DCO Submission

Appendix 3.3: Summary of Stage 1 Non-Statutory consultation comments

Document 6.3C

Oxfordshire Railfreight Limited

**BRIDGE PLANS  
ARDLEY ROAD / B430  
ARDLEY BYPASS  
OVERBRIDGE (BRIDGE 16)**

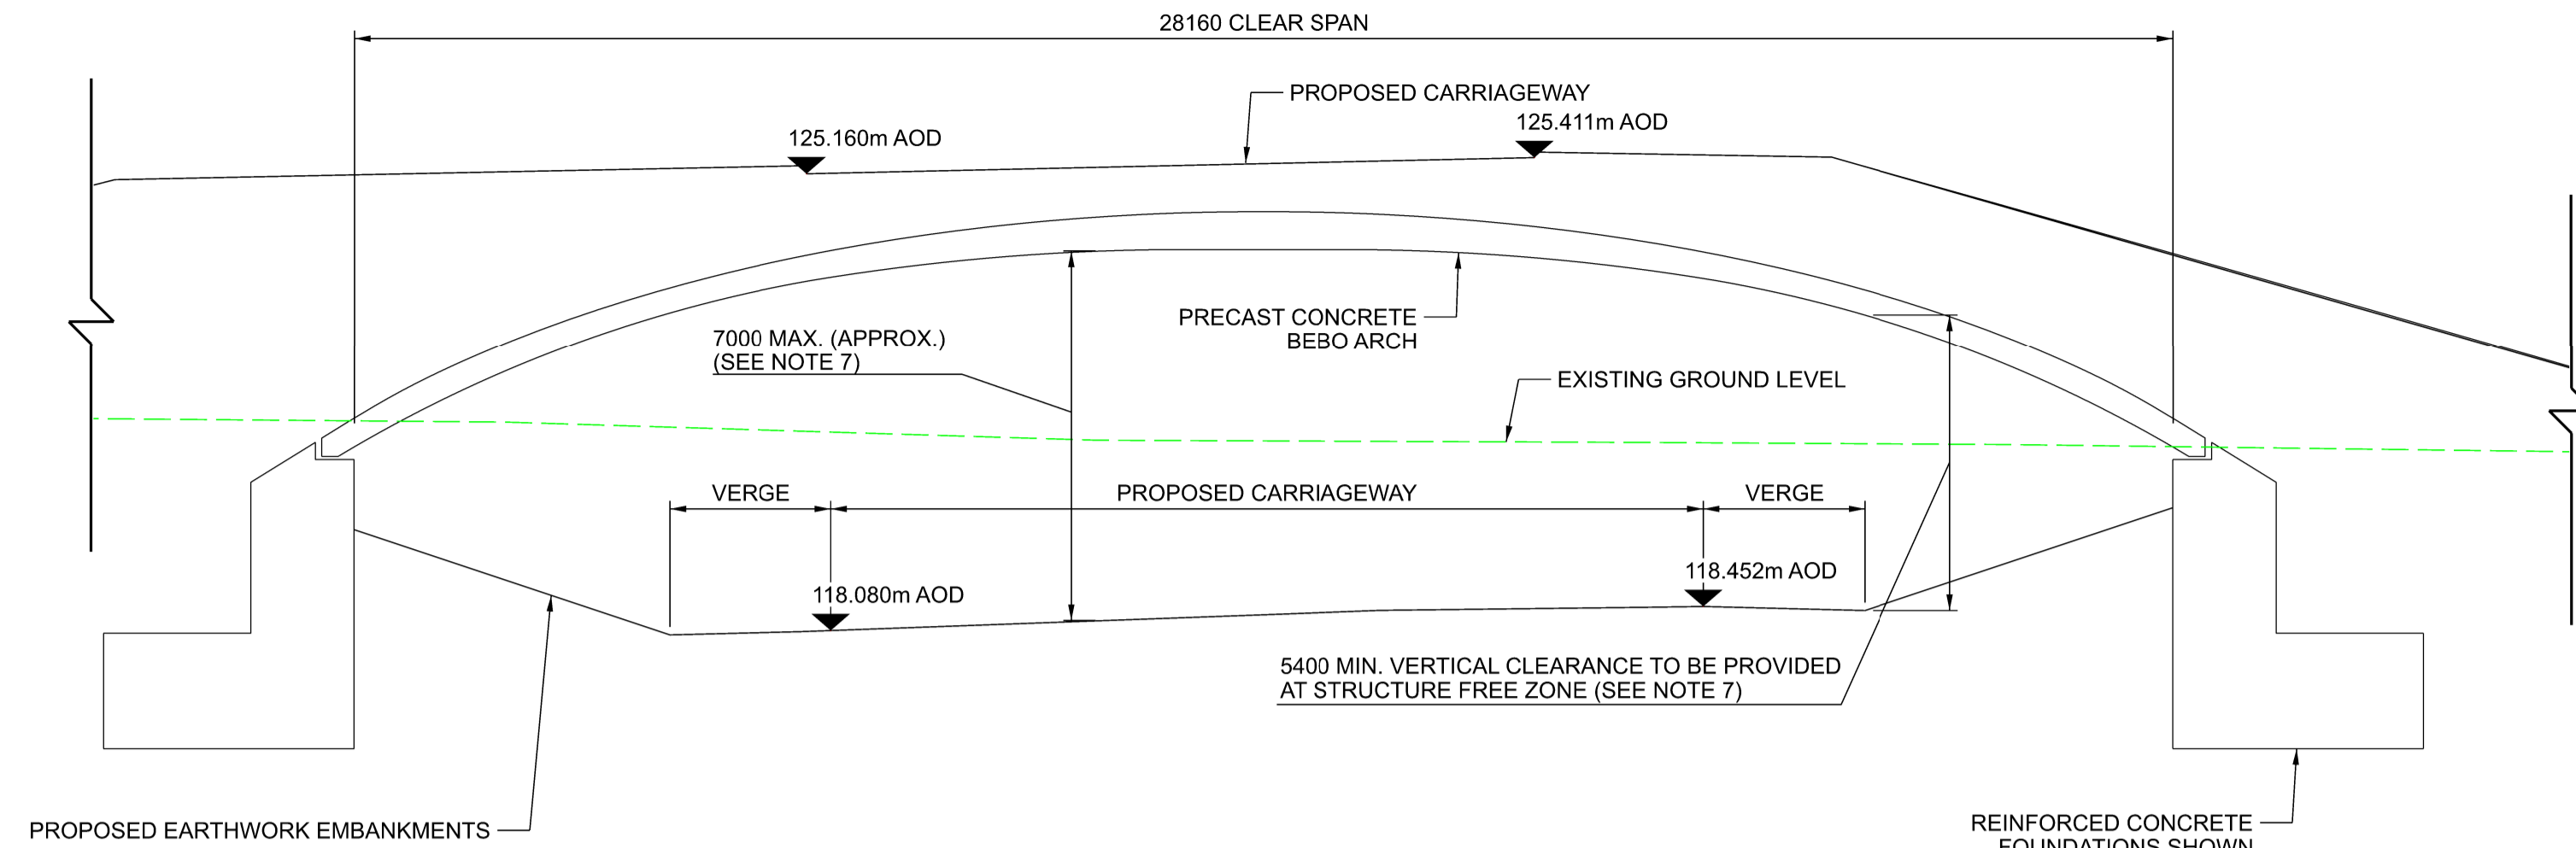
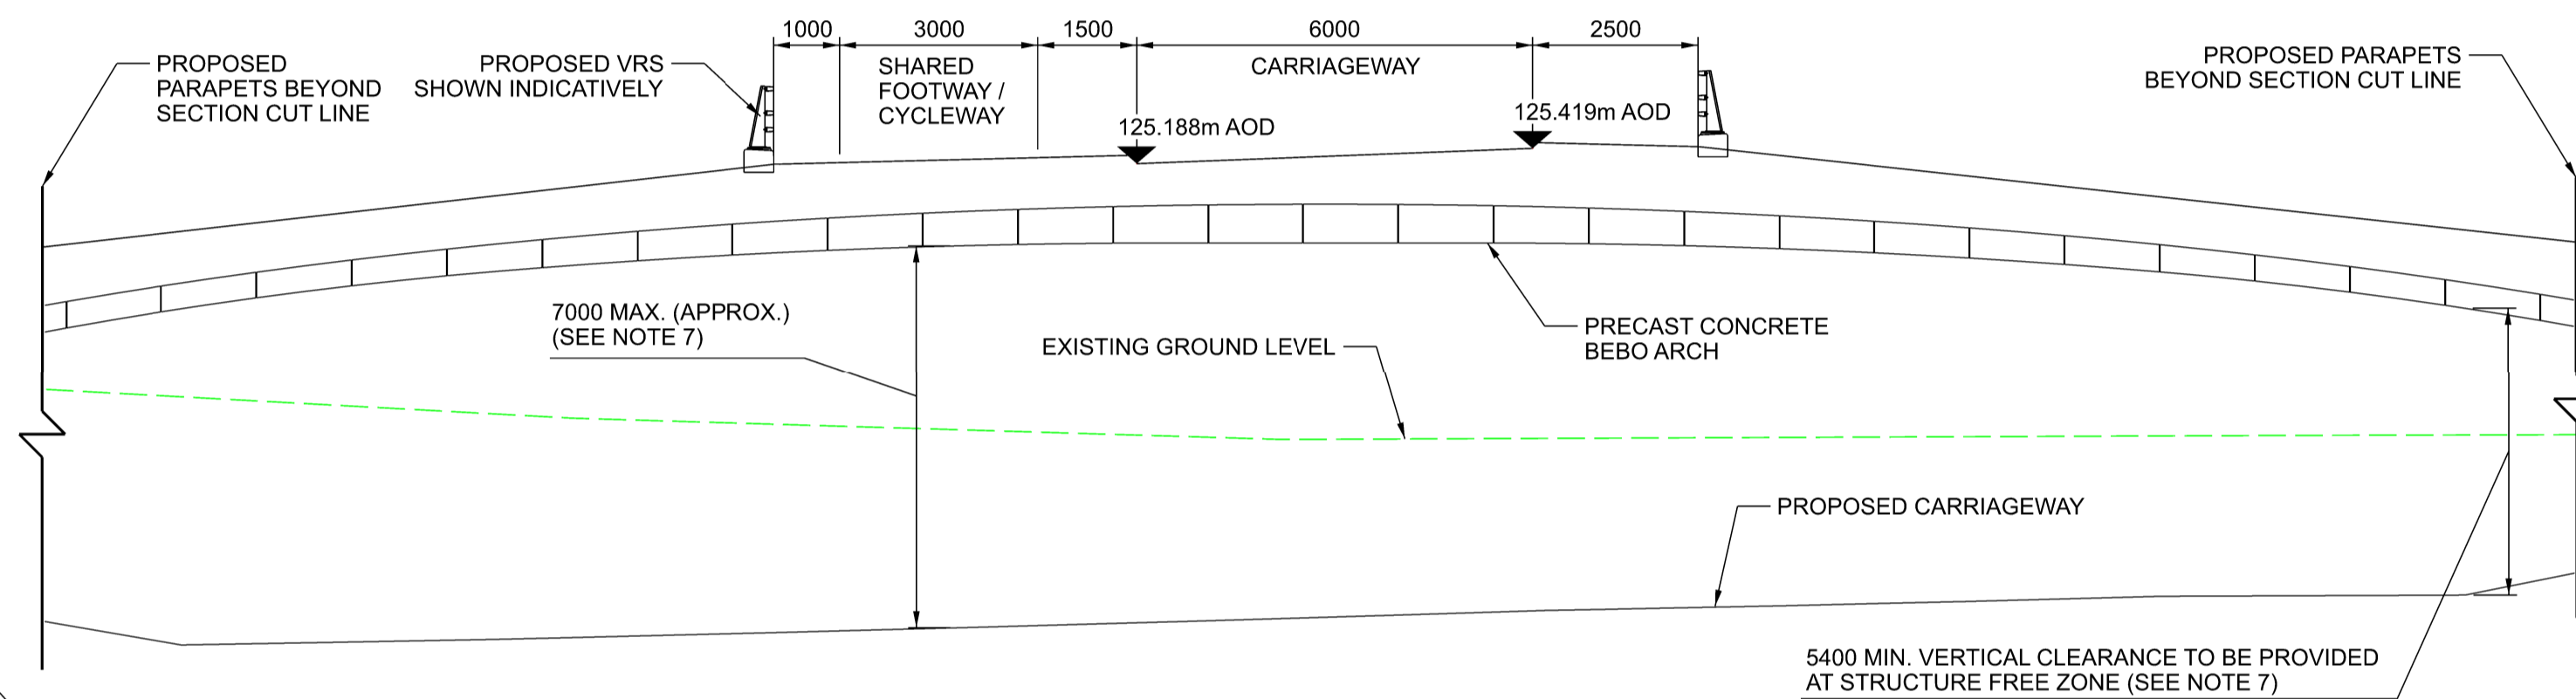
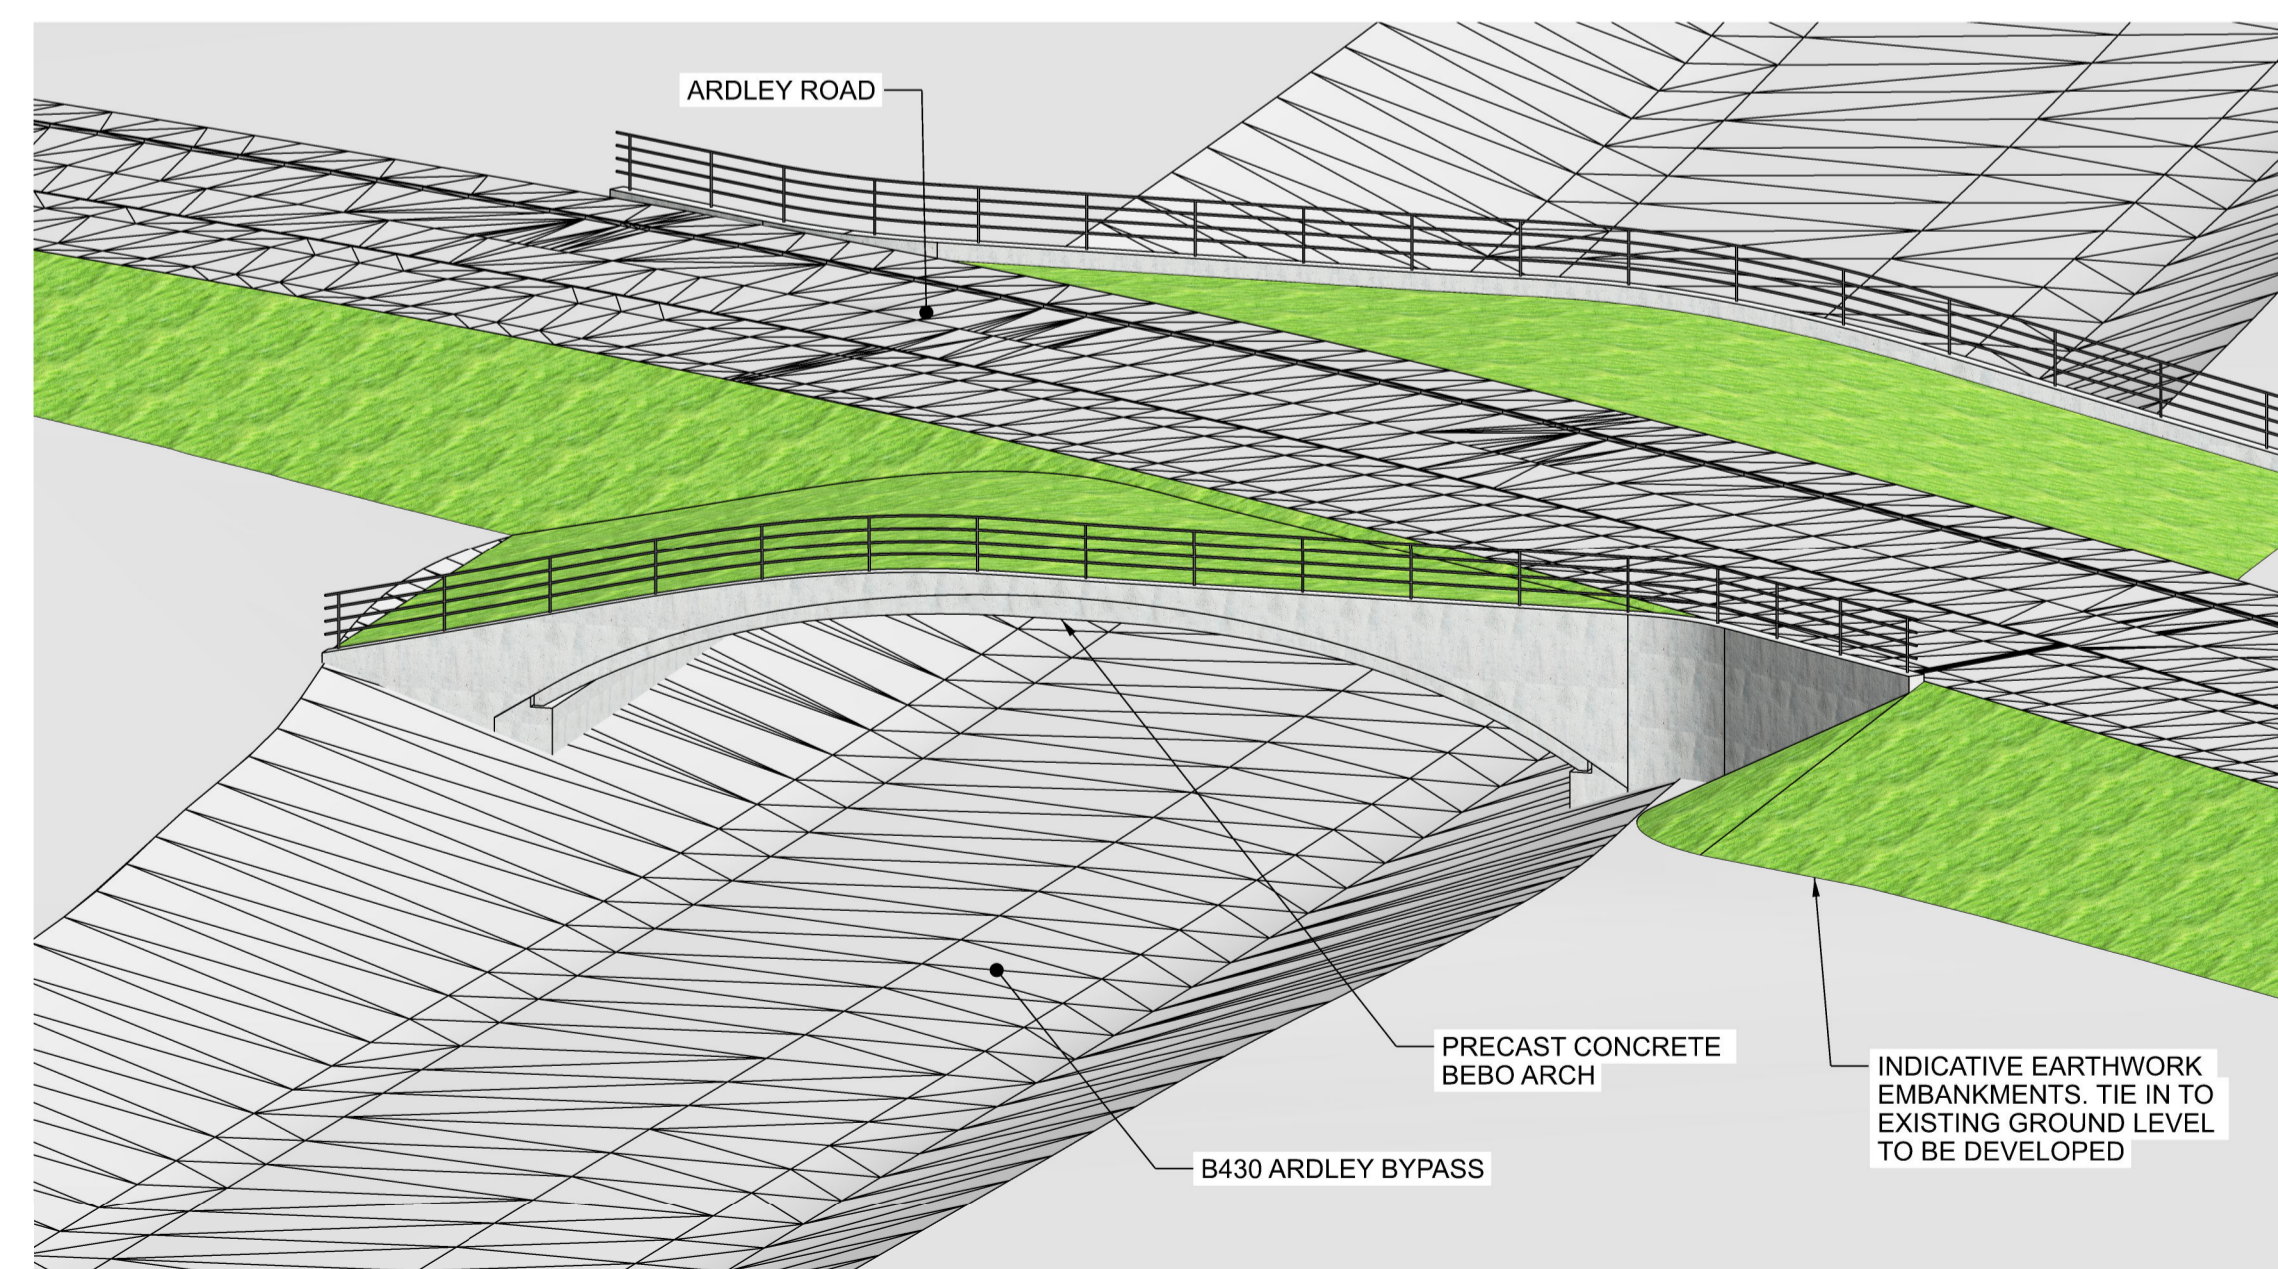
38	Further detail is required where bridges and underpasses connect bridleways.	Details were provided as part of this Stage 2 consultation and as part of the DCO submission (see Bridge Plans Document 2.12)
Innovation – vehicle charging; local power generation; communication		
42	OCC note implications for energy supplies and space at the site for HGVs to refuel via alternative energy sources	Noted.
